TURNER

12 August 2016

I write in response to the letter issued by SOPA on the 15th of July 2016 by Ross Coggan in regards to the modification of the through site link.

Project Title  
**JEWEL RETAIL**  
1 BURROWAY RD. WENTWORTH POINT, THE WHARF SITE.  
SYDNEY OLYMPIC PARK  
Drawing Title  
**ROOF PLAN & SECTION**

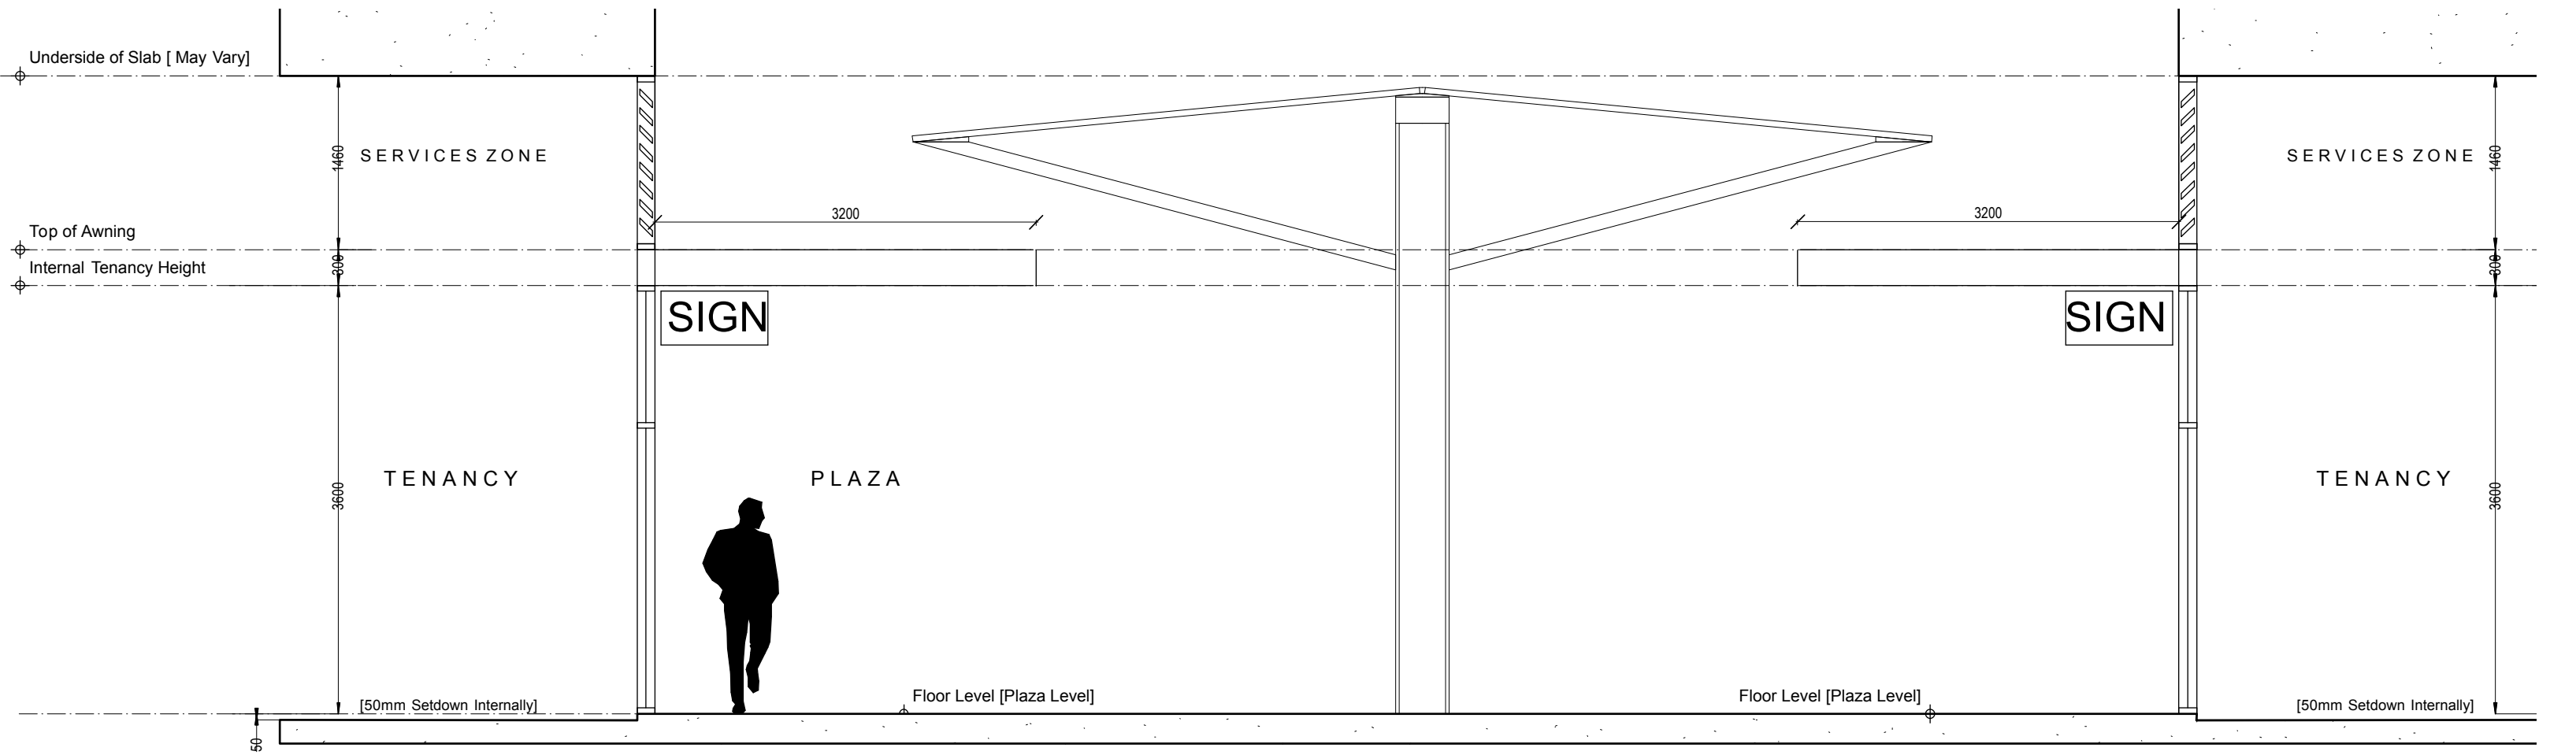
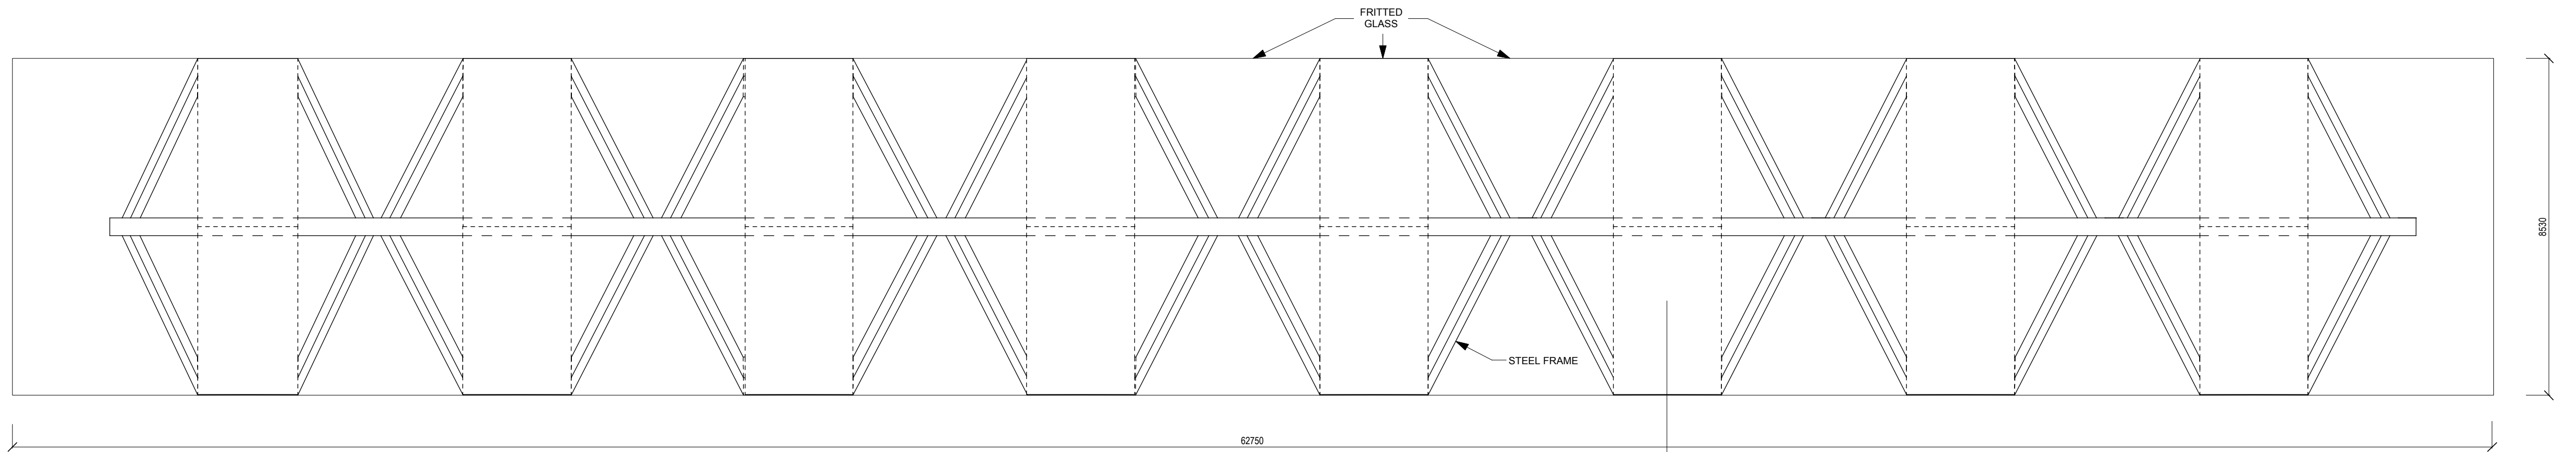
SOPA - The proposed steel support structure has a heavy appearance. The structure should be a light weight, finely detailed support system.

SOPA - The centralised columns obstruct the space. Consideration should be given to repositioning the columns along both edges of the space, which should also enable the structure to be minimised.

SOPA - Height of the canopy is too low and appears to enclose the space. The height of the glass canopy should be at least 7m to provide for a grander scale and improved amenity.

SOPA - Limited natural light. Consideration should be given to providing additional glazing to the retail awnings in addition to the proposed glass canopy and the canopy should be fully glazed.

The design is showing the engineers minimum requirements in steelwork structurally. The design has been optimised to minimise the overall steel sizing's throughout the design process, the colouration was an added consideration hence the application of white paint, further lightening the structures overall appearance.

Glazing with a soft frit pattern is proposed allowing light penetration into the space, with intermittent solid portions down the length of the roof providing some shade protection.

Having structure either side of the proposed would double the amount of structure.

The heights have been carefully considered so the scale of the glazed canopy is both relevant to the awnings both sides it sits above, and the pedestrian scale below. Lifting the canopy height to 7M would depart from both these principles weakening both aesthetic and use.

The canopy is largely made of clear glass (with frit) in order to not weaken the natural light, rather to manage it. Regarding the solid awnings over the retail tenancies, these have been shown for some time on the approved DA drawings. This approach stands relevant to many retail precedents in Sydney and abroad.
